From: Laura Gibbons <Laura.Gibbons@arun.gov.uk>
Sent: 01 July 2021 13:35
To: Amy Myer <Amy.Myer@arun.gov.uk>
Subject: RE: Y/80/21/DOC - REVISED ENGINEER COMMENTS

I therefore recommend discharge of condition 7. The following should be referenced in any approval:

- 424927/201P4 Surface Water drainage layout 1 of 3.
- 424927/202P4 Surface Water drainage layout 2 of 3
- 424927/203P4 Surface Water drainage details 3 of 3

KEY	
	Location of soakaway tests Result & Depth shown
	Groundwater monitoring results depth of highest recorded level

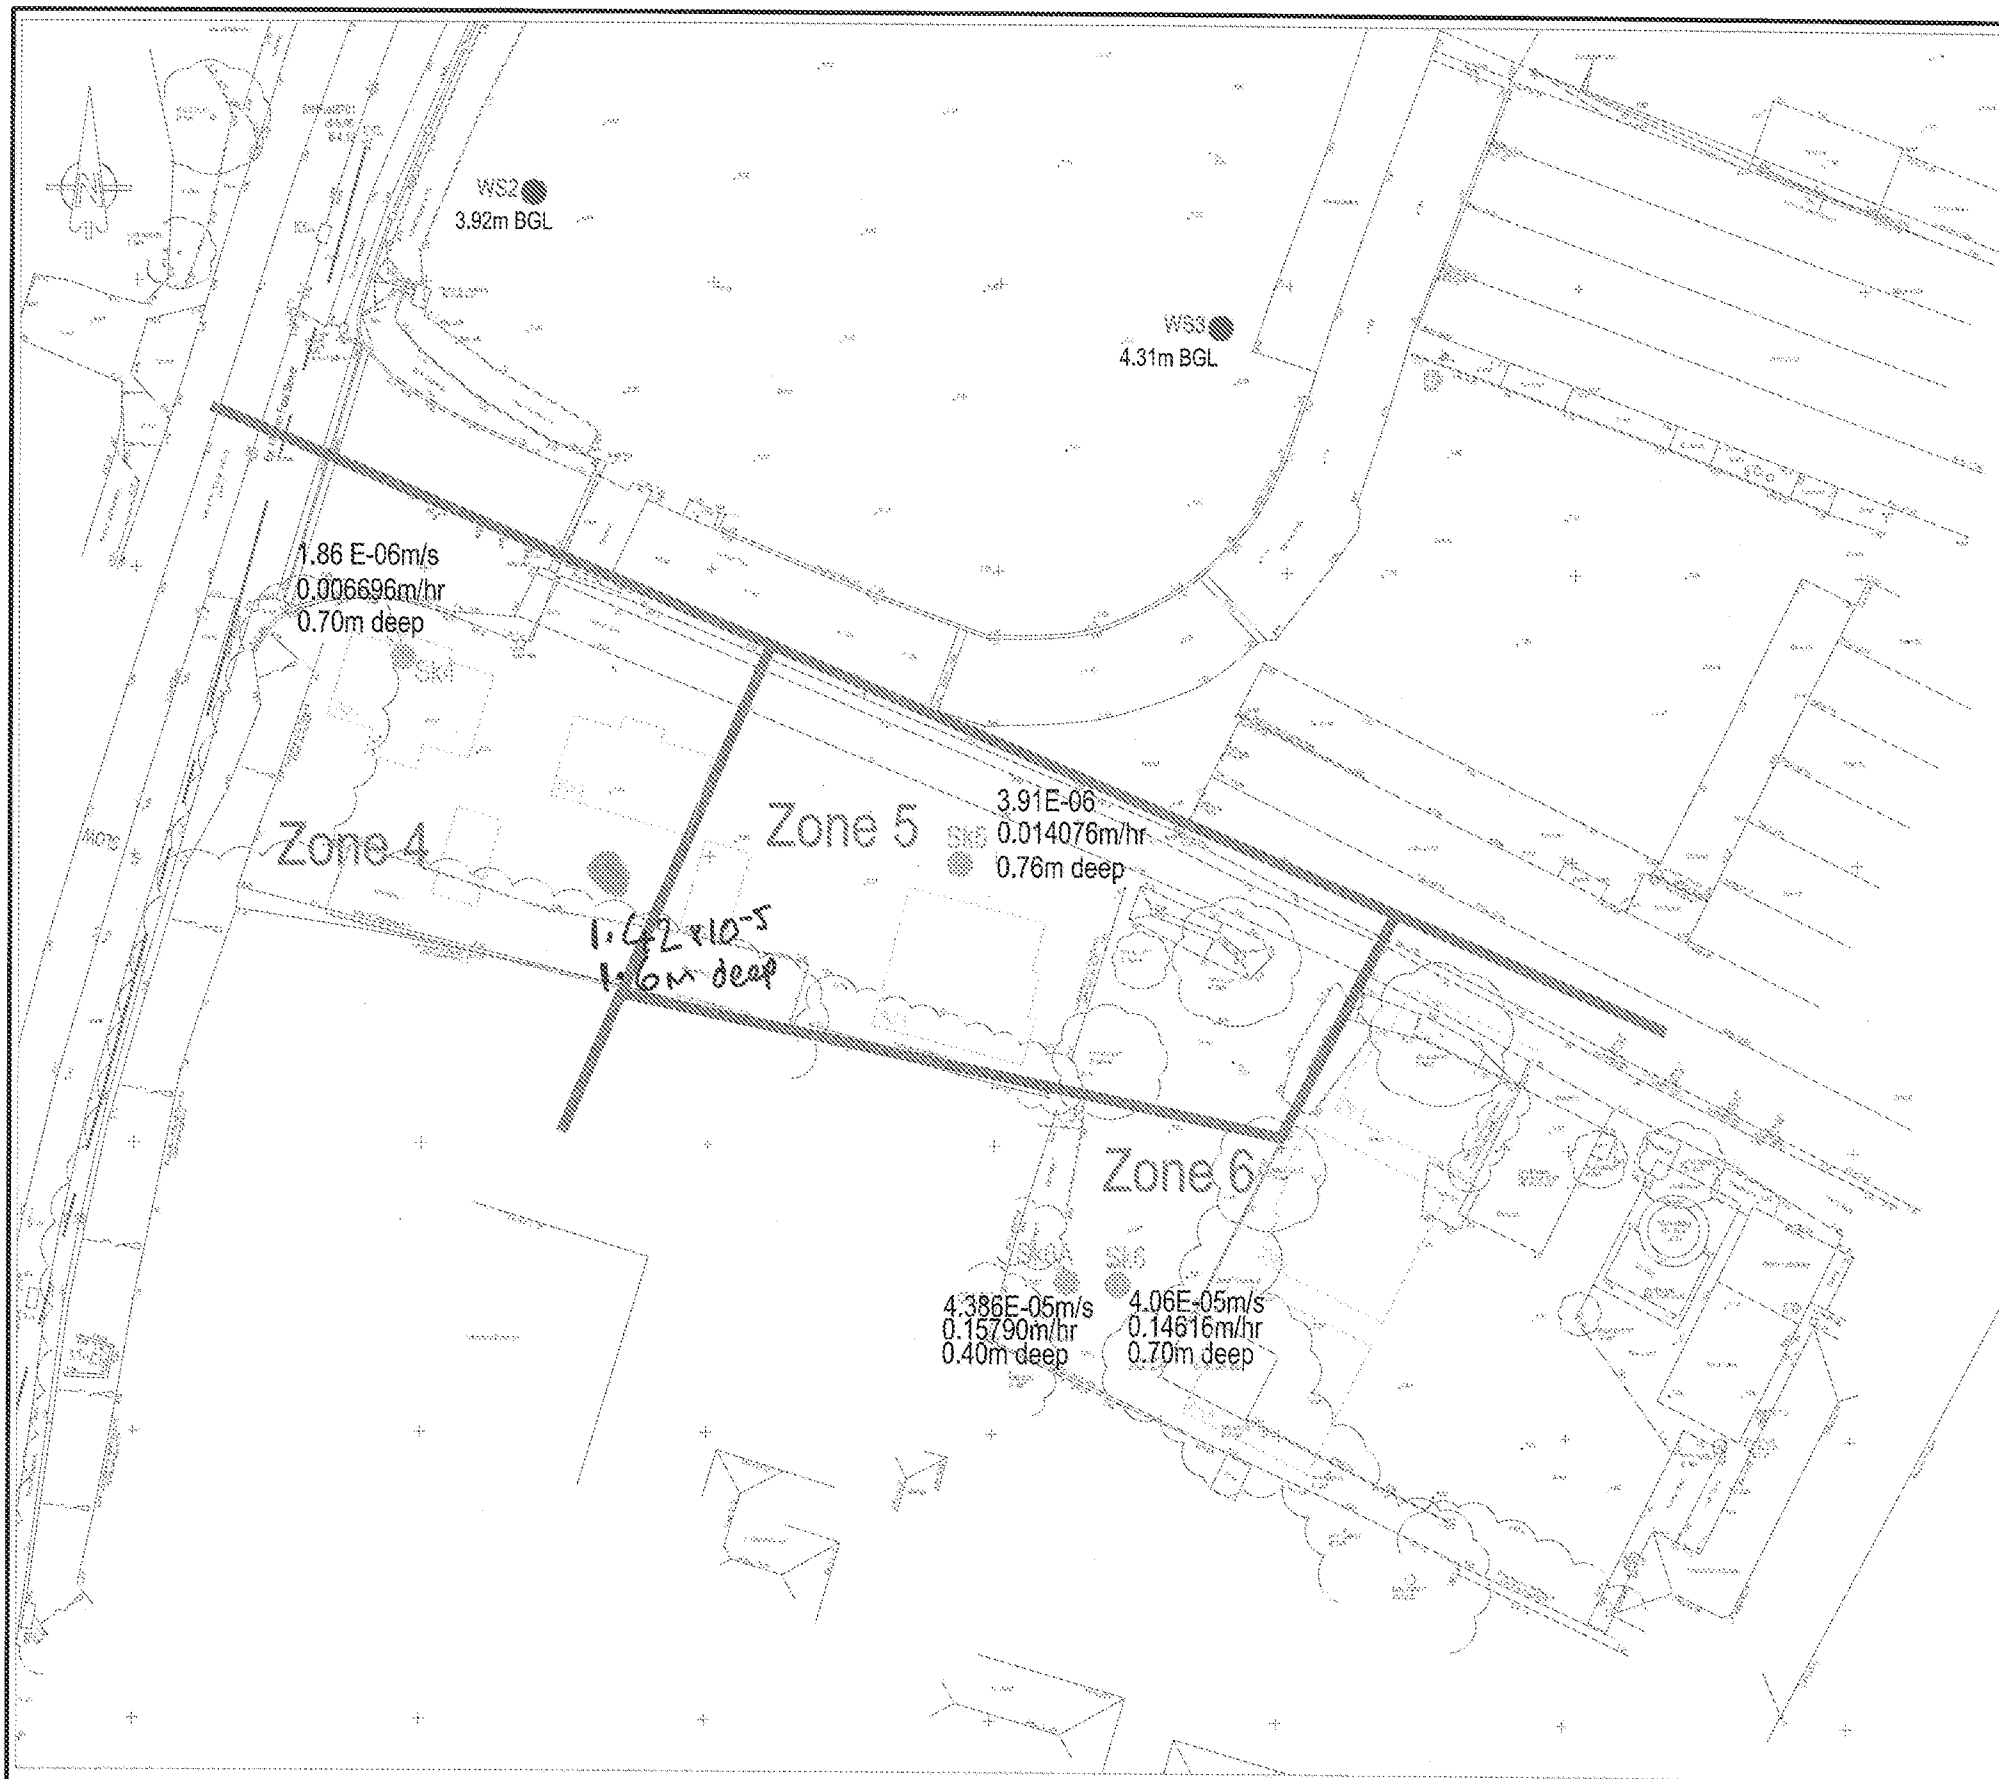
1. I have noted infiltration testing date / locations on the plan and attached to the calculations.
2. I have applied the shallower depth infiltration testing results to the permeable paving design and updated the calculations / drawings. Sub base depth increased to 400mm.
3. Drawings updated (and attached) with permeable paving finish and formation levels.
